**CITY OF ALBUQUERQUE
PLANNING DEPARTMENT
Development Review Board
June 16, 2004
Comments**

PROJECT # 1003486

APPLICATION # 04-00887

RE: Lots 3, 4, & 4A, Apodaca & Sedillo Addition/sketch

**PLAT OF
LOTS 3-A & 4-A-1, BLOCK 1
APODACA AND SEDILLO ADDITION
WITHIN SECTION 29, T. 10 N., R. 3 E., N.M.P.M.
CITY OF ALBUQUERQUE
BERNALILLO COUNTY, NEW MEXICO
JUNE, 2004**

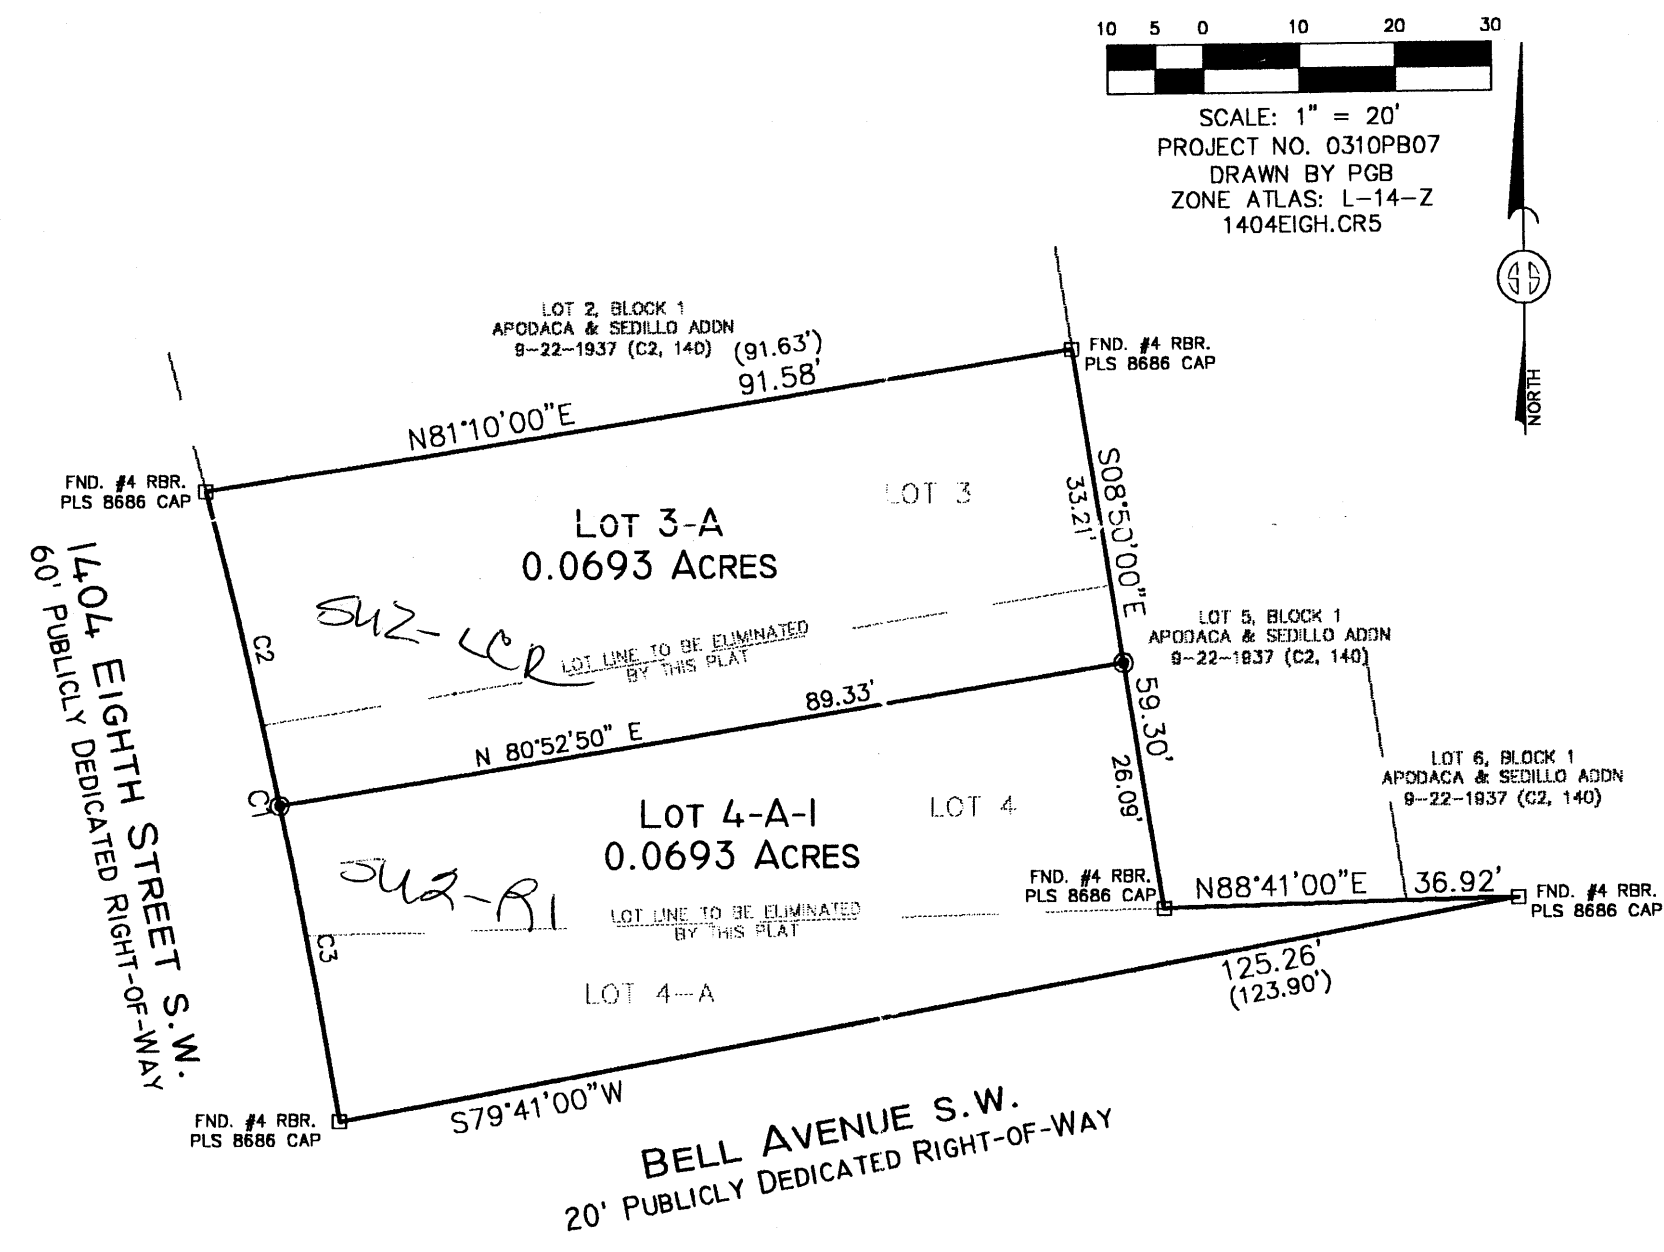
Barelas SDP on pages 81 & 83 give the requirements for the 2 zones on this property.

A zone change is necessary if applicant wishes to combine any portion of 2 differently zoned properties together.

In the sector plan, R-1 zoning minimum lot size is 4,800 square feet and 40 feet wide. The front yard setback is reduced to 10 feet except 20 feet is required for garages & carports. Uses permissive in the RT zone are permissive on the R1 property.

The LCR land use corresponds to the RC/Residential Commercial in the Zone Code with the exception that the non-residential uses listed as permissive in the Zone Code are not limited by floor area.
